Sent: 15 August 2026 11:12
To: DC Admin
Subject: Re: Bellway Planning application ref 2025/93355

Below are our formal objections to the additional information submitted by Bellway. We believe the issues raised remain unresolved and continue to present significant risks to road safety, local infrastructure, and community wellbeing.

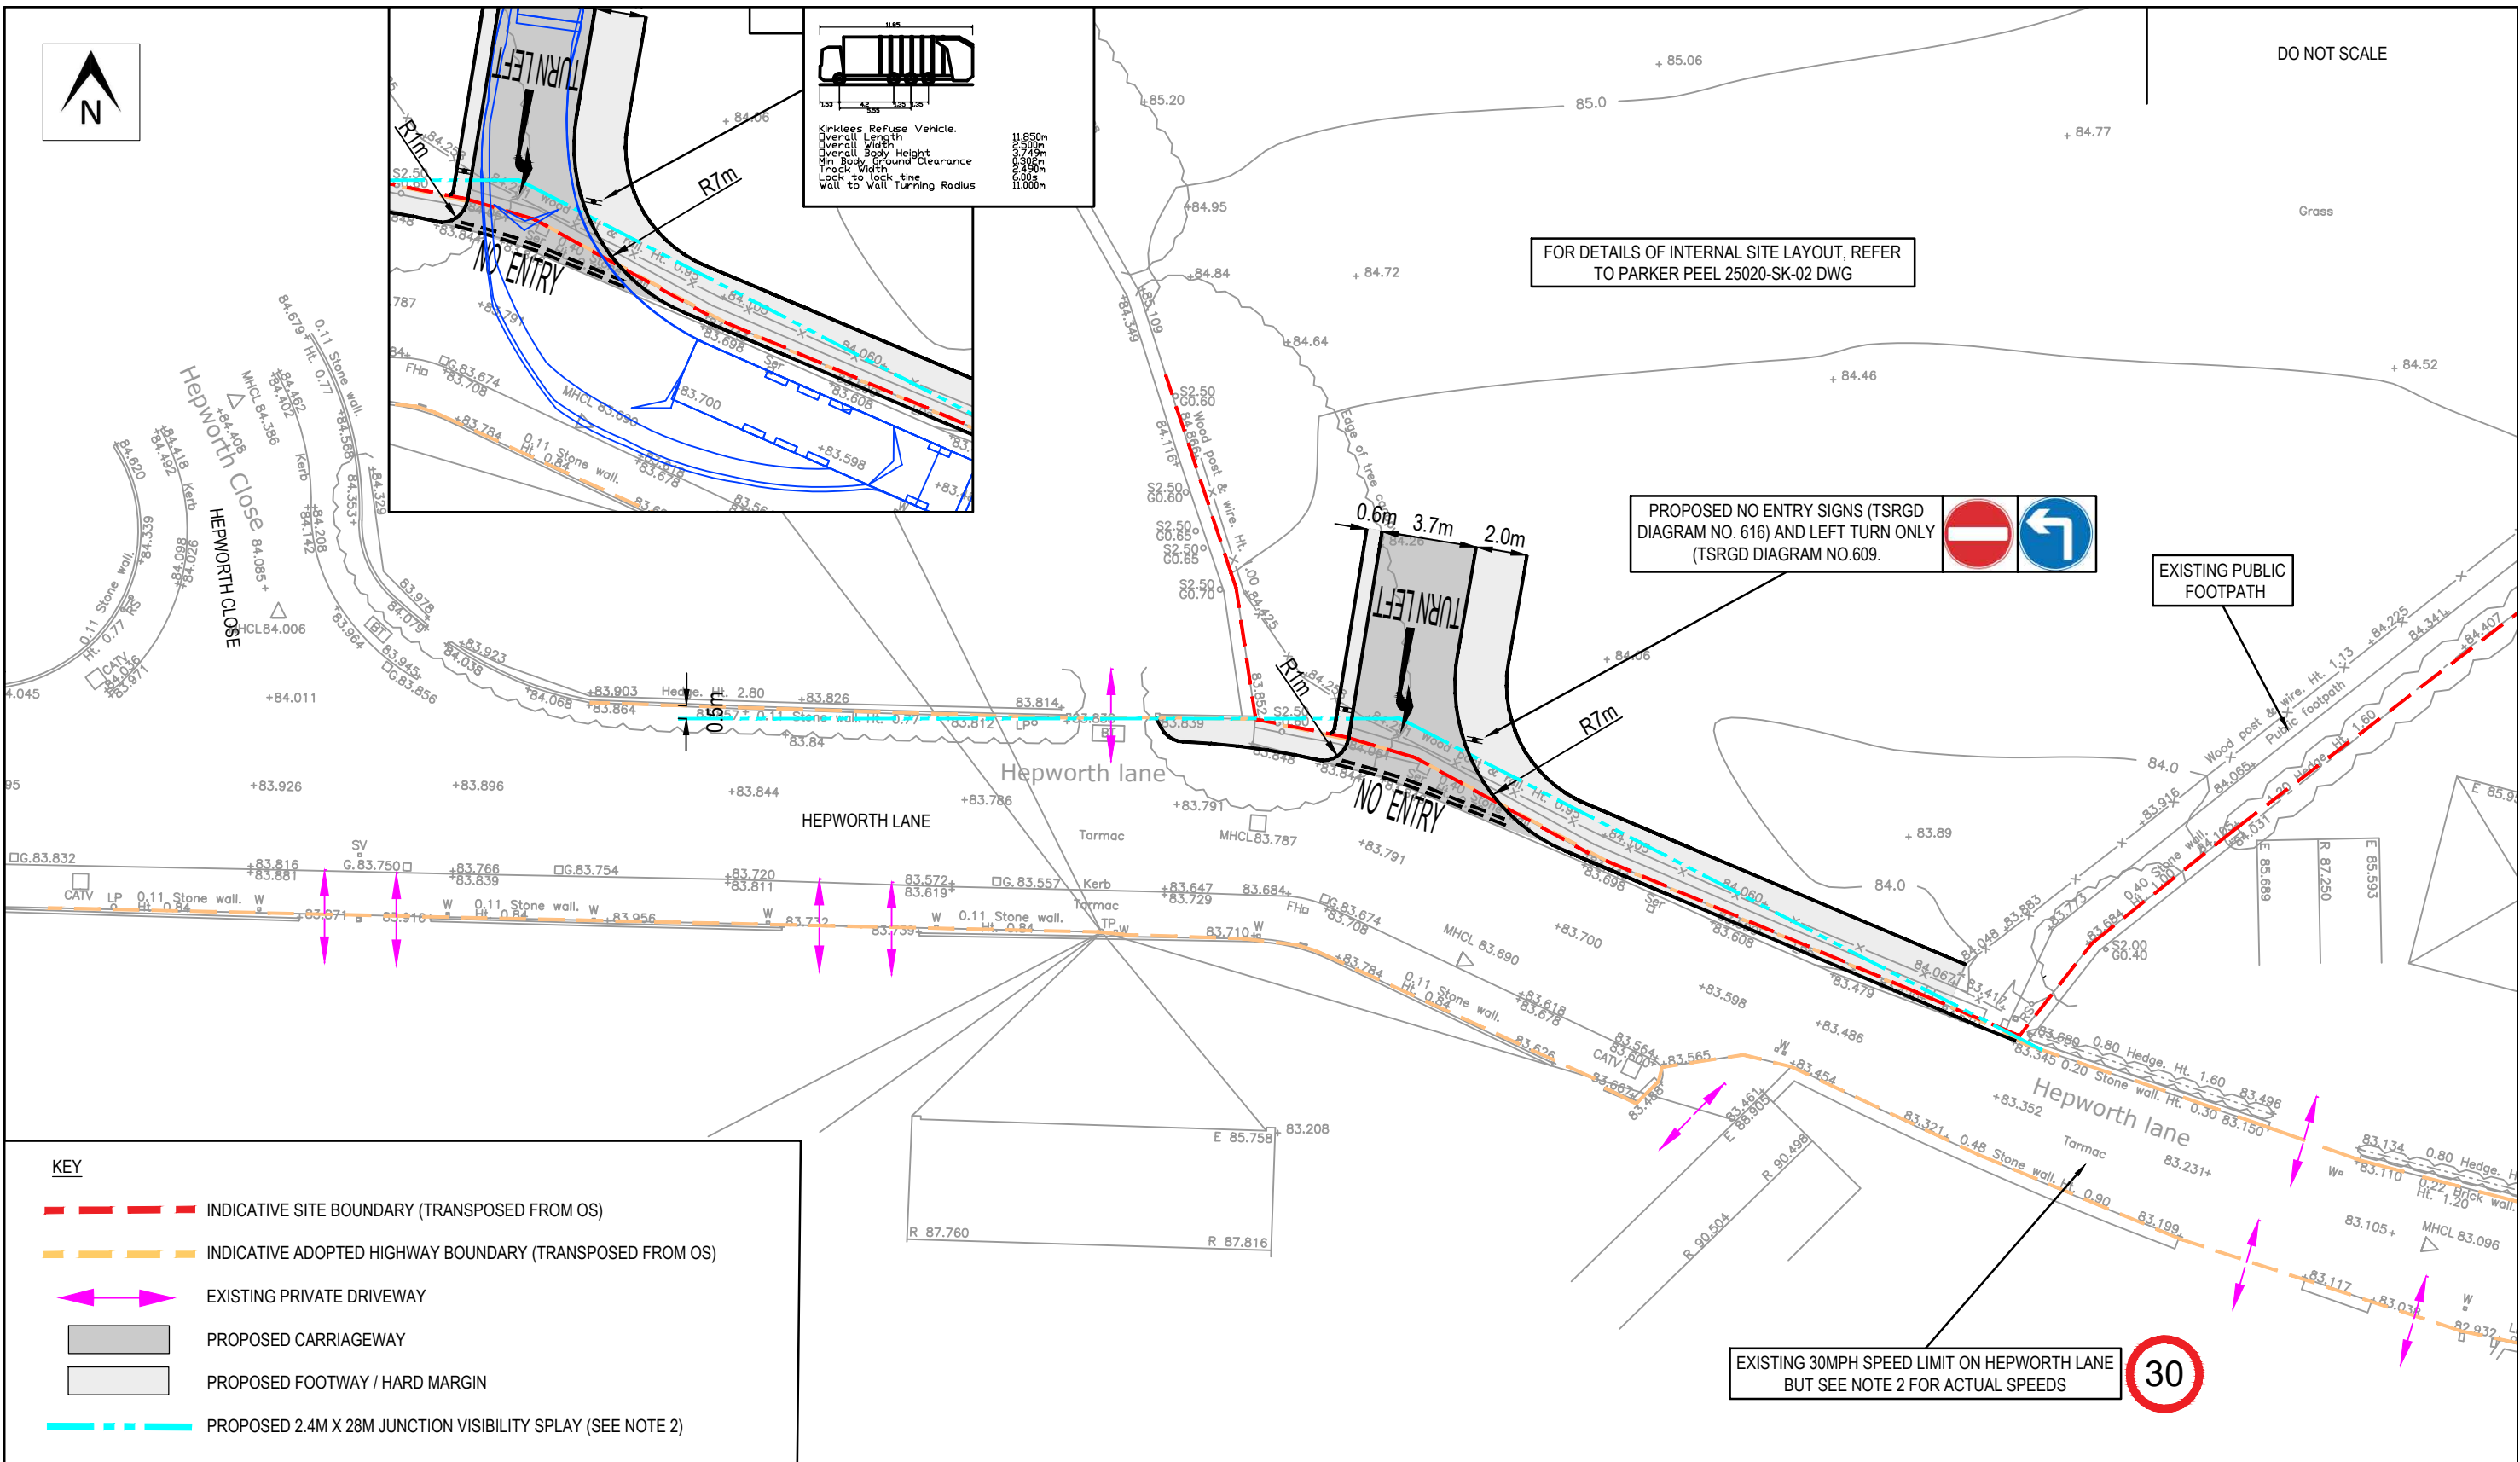
Bellway's proposal for an entrance/exit allowing vehicles to turn left or right presents serious problems:

- Turning left leads immediately to Shillbank Lane. The narrow gap means vehicles cannot enter Hepworth Lane while others wait to turn onto the main road.
- Turning right leads to a very narrow, single-width, one-way section of Hepworth Lane. Vehicles then reach a blind exit onto Wellhouse Road, where properties on the left block visibility.
- Wellhouse Road itself is narrow, and when cars are parked on both sides, only one vehicle can pass at a time.

To accommodate the proposed traffic, Wellhouse Road would likely need to become a one-way system. This would negatively impact the cricket club, residents, and emergency response times.
